PINS REF NO: TRO10060-000007 (A12 Chelmsford to A120 Widening Scheme)

DESCRIPTION: Planning Act 2008 (as amended) and the Infrastructure Planning (Environmental Impact Assessment) Regulations 2017 - Scoping Opinion Consultation

PROPOSAL: Application by Highways England for an Order granting Development Consent for the A12 Chelmsford to the A120 Widening Scheme

This letter therefore constitutes Braintree District Council's response to the Environmental Impact Assessment Scoping Report consultation issued by the Planning Inspectorate.

**FIGURE 13.1**

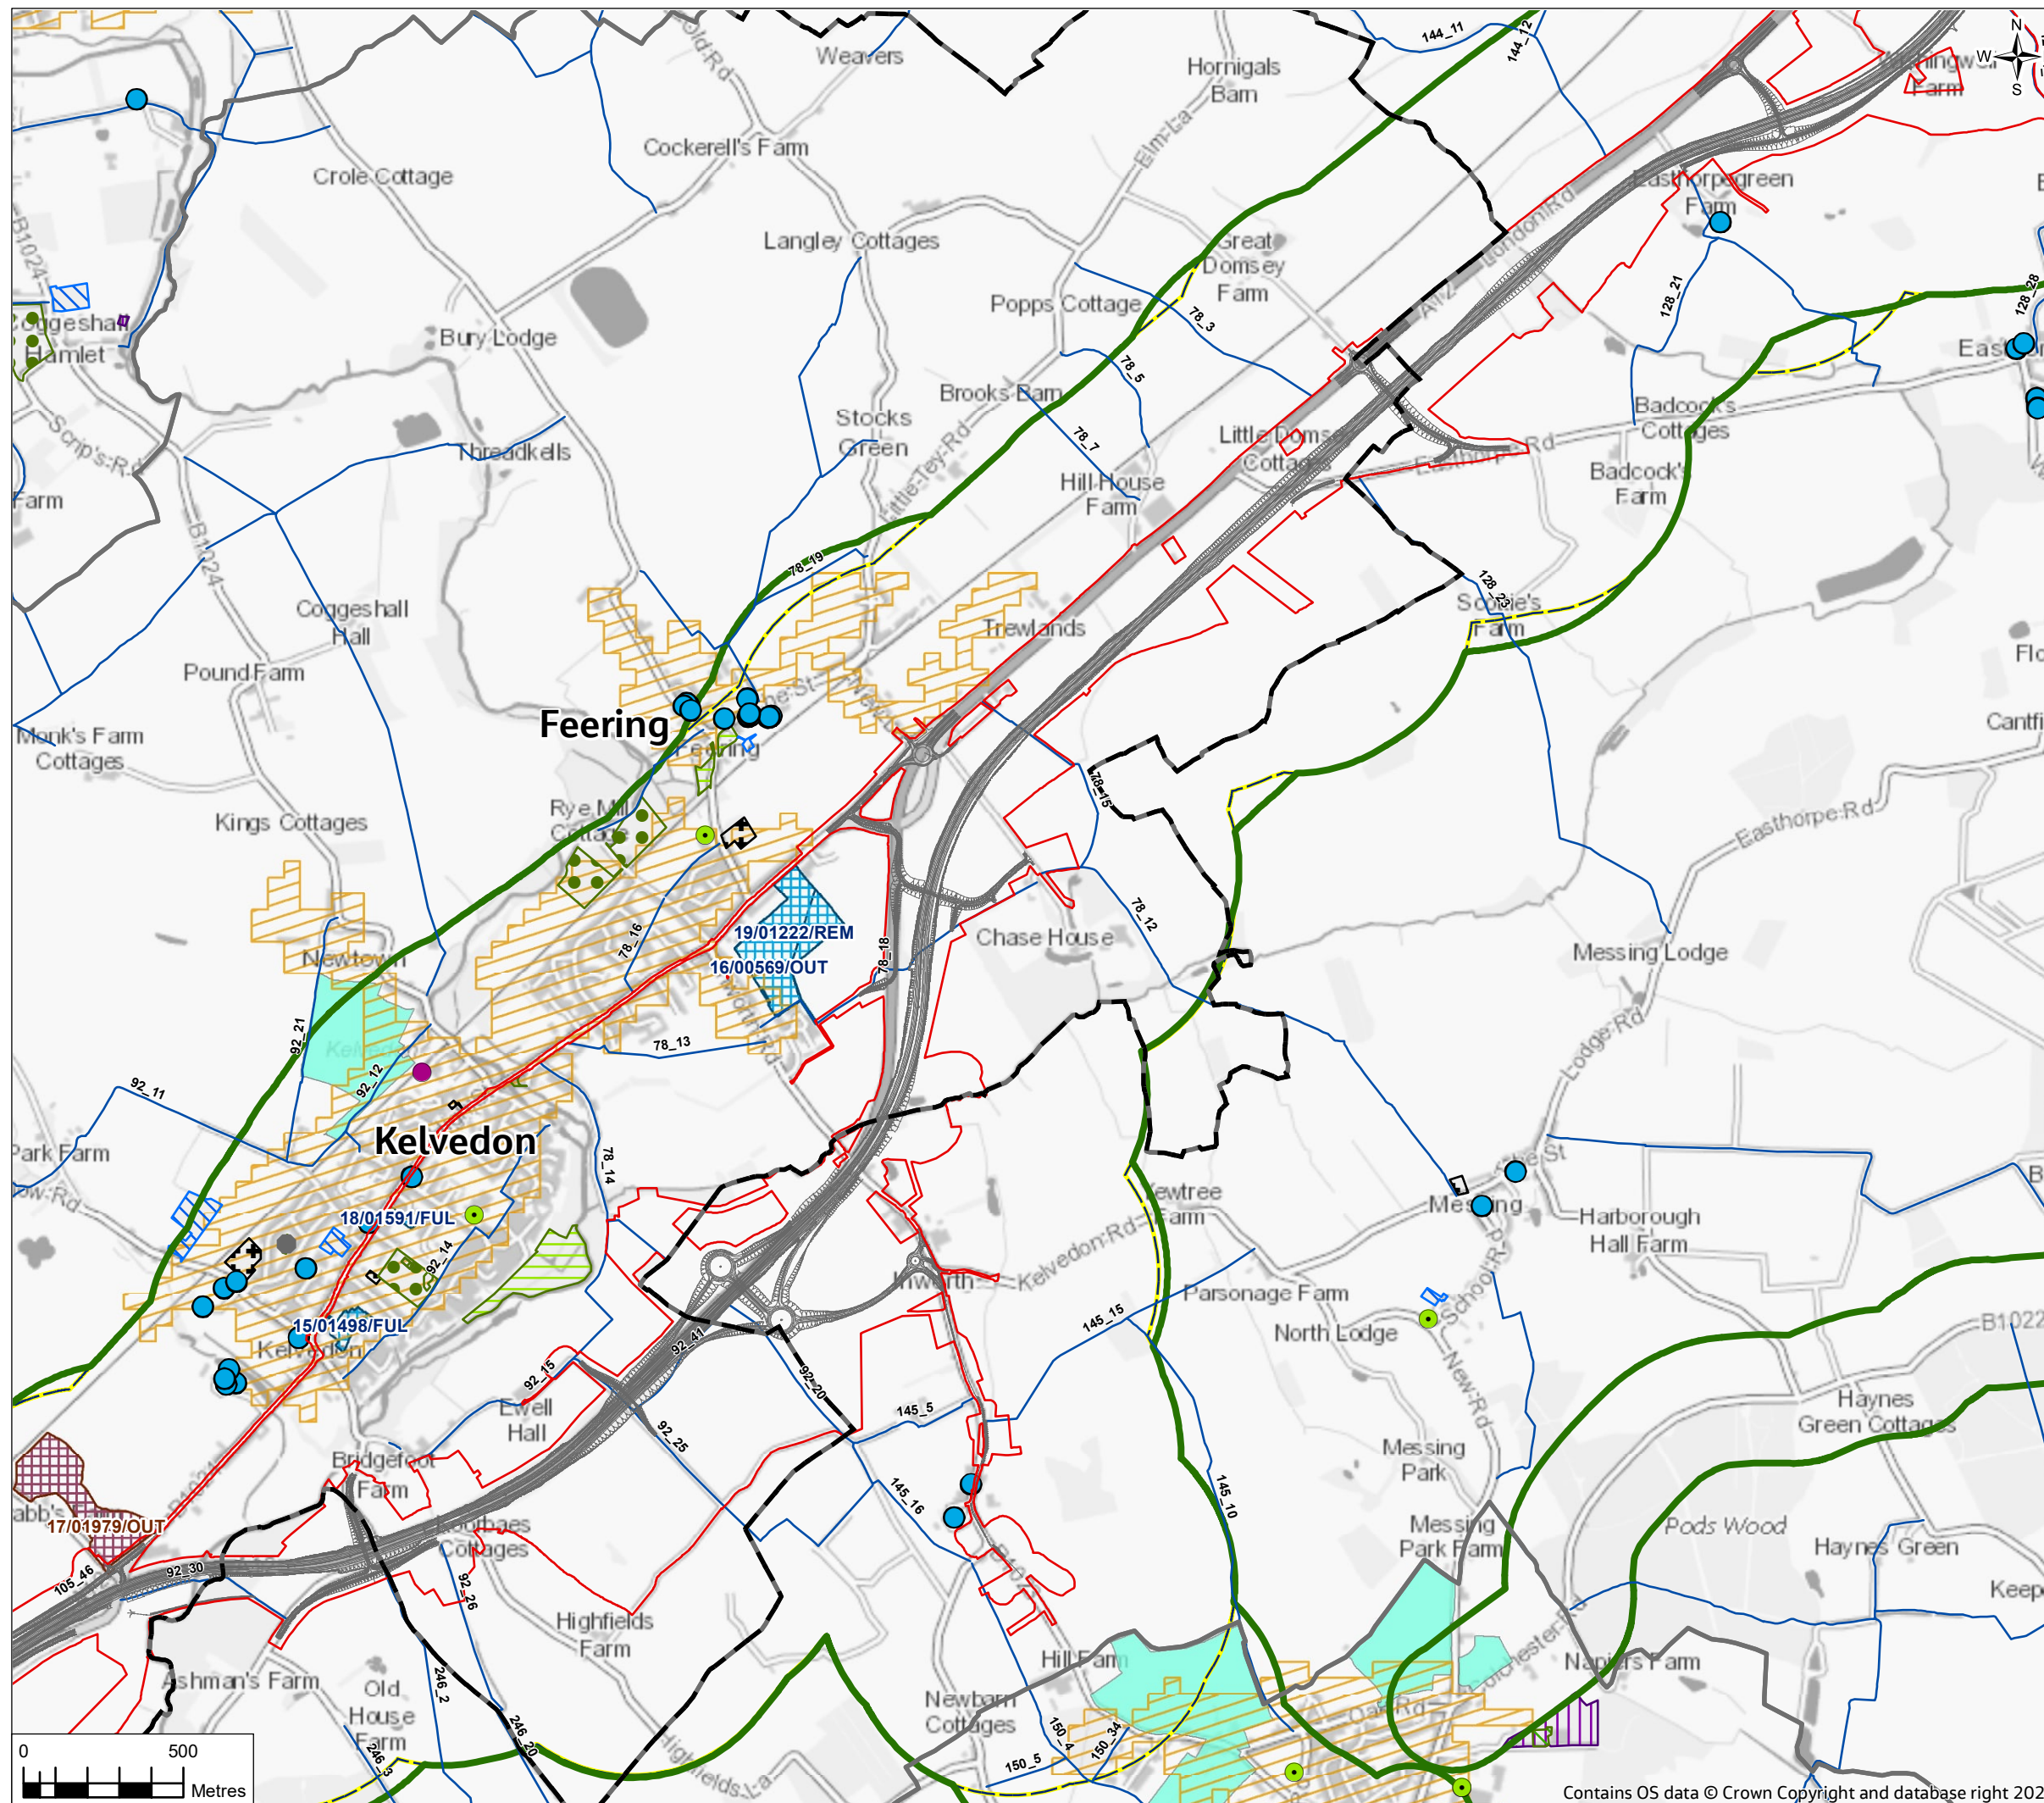
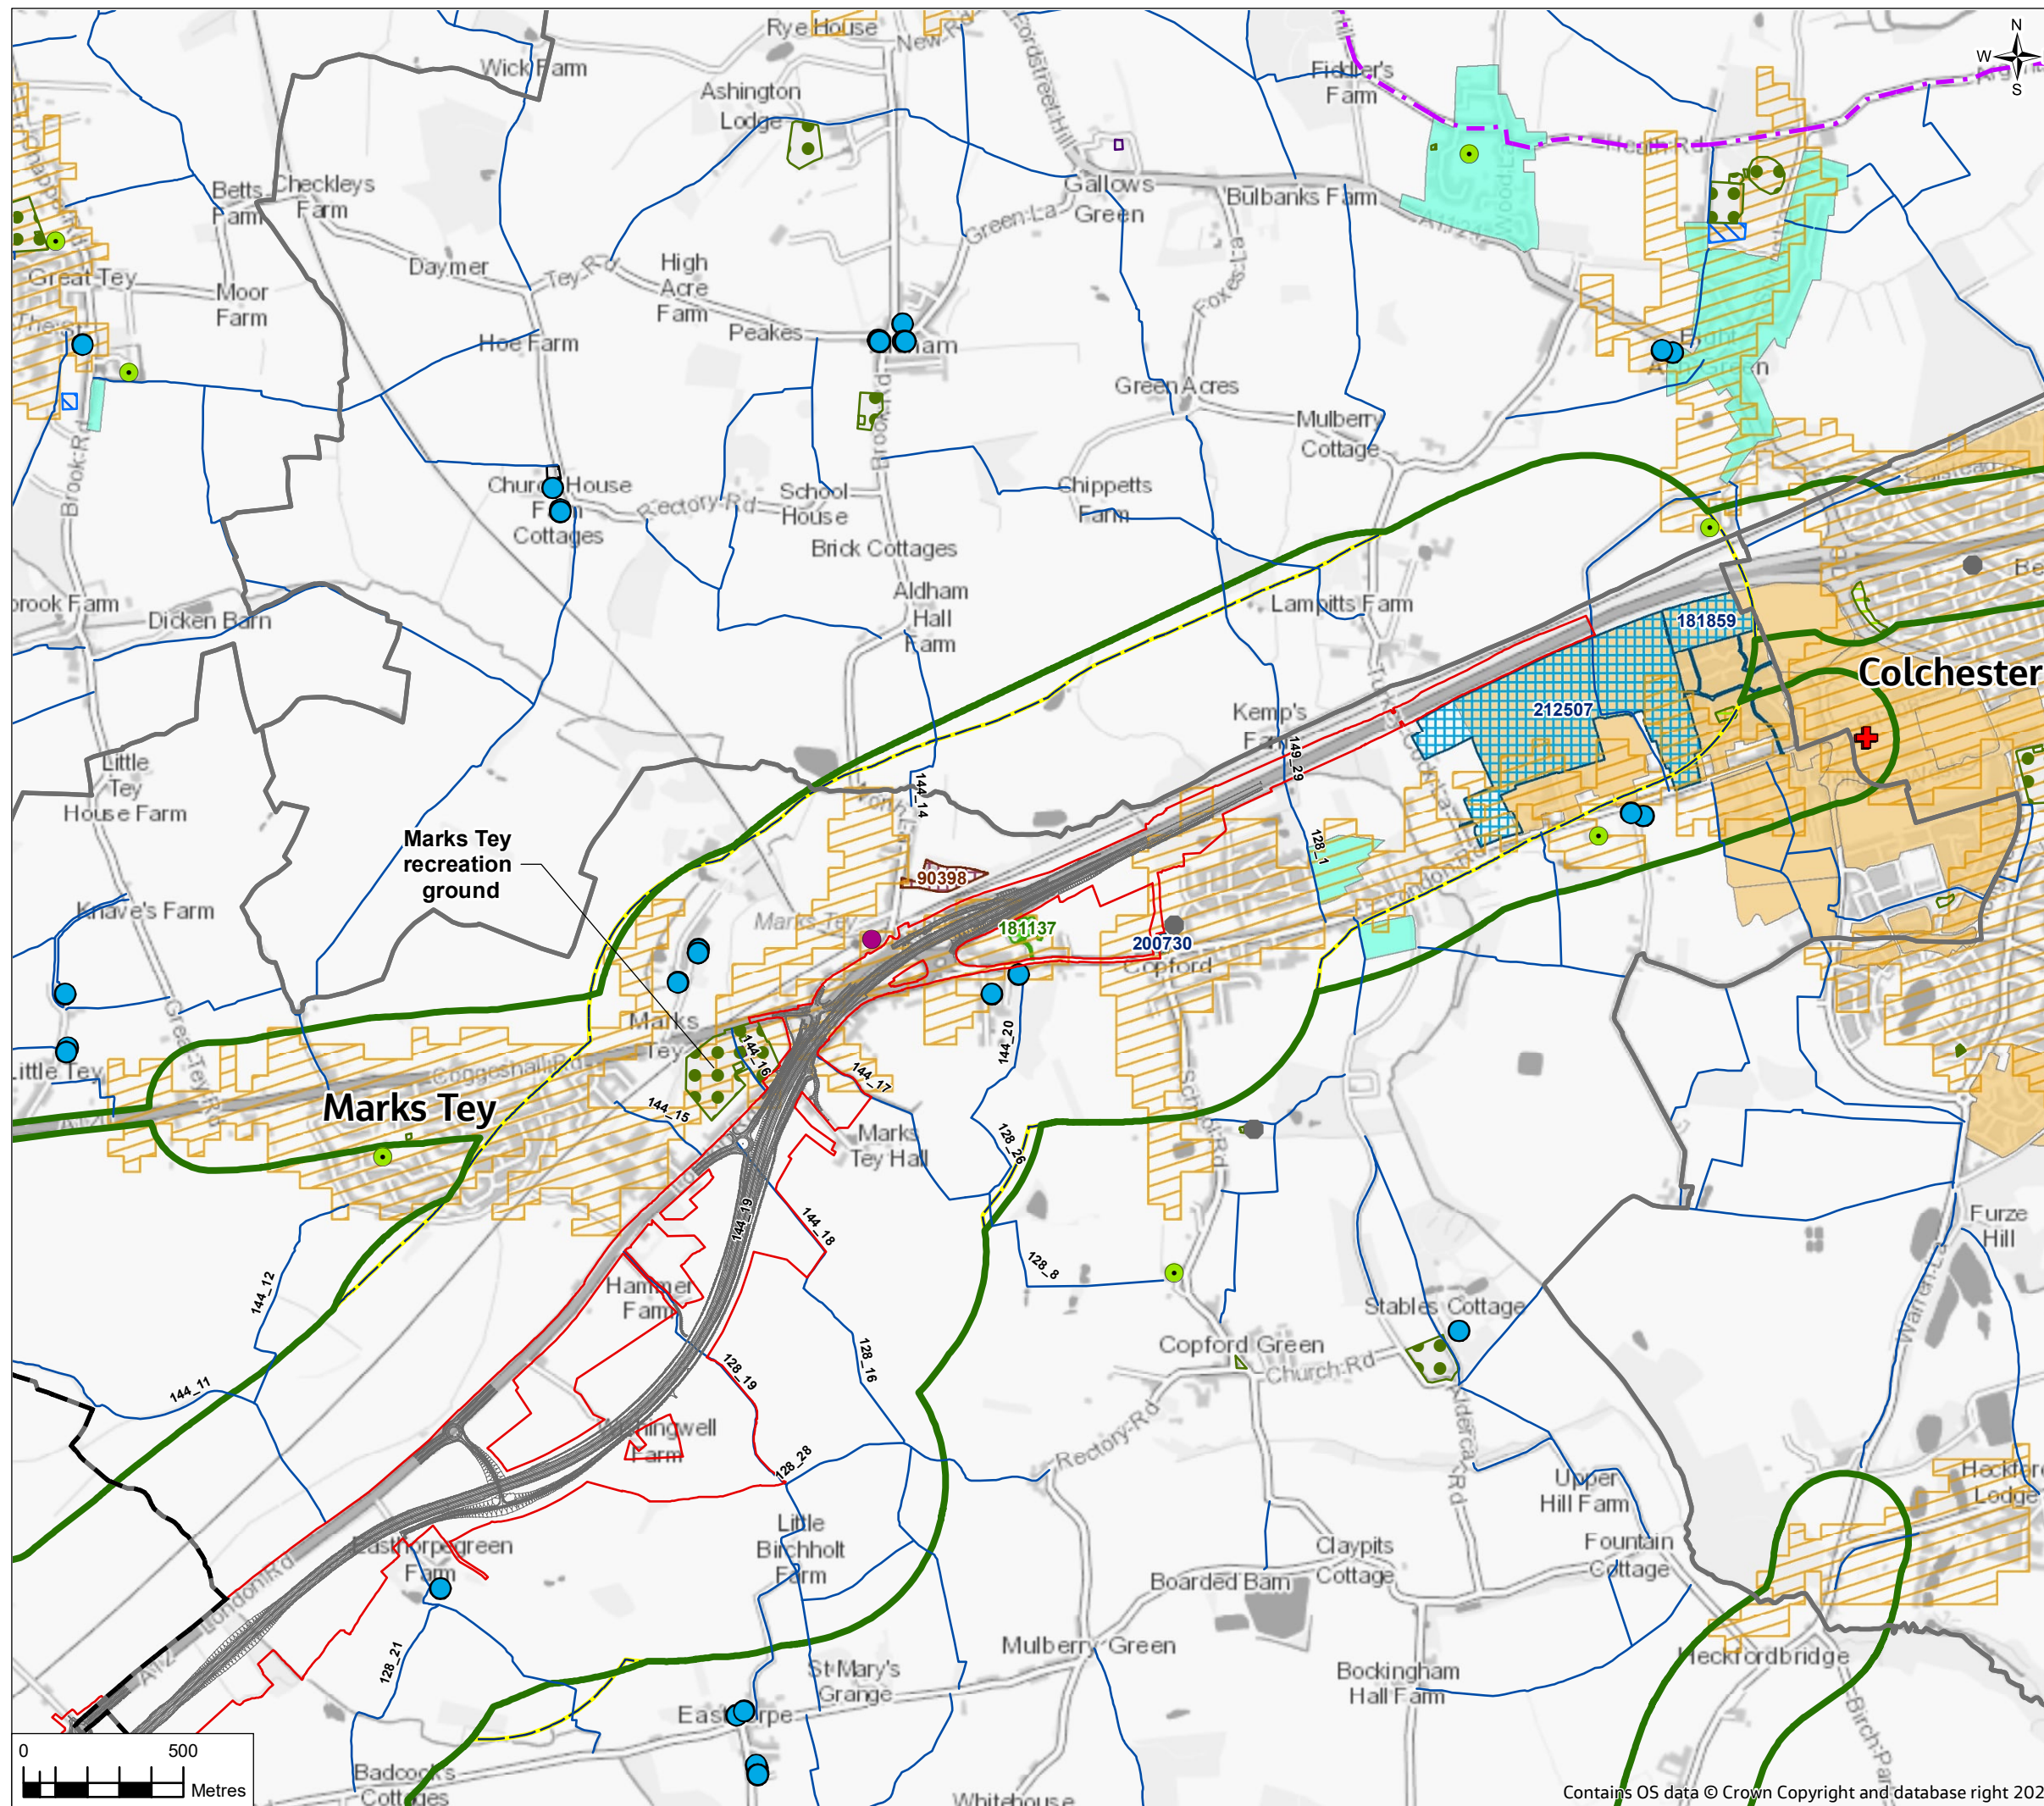
The Scoping Report sets out housing allocations and applications in the study area in Table 13.2 (and corresponding figure 13.1 in appendices). Number of houses allocated, status of planning applications and extent of residential and strategic growth locations are not quite as accurate as they could be but is a reasonable broad reflection of housing growth.
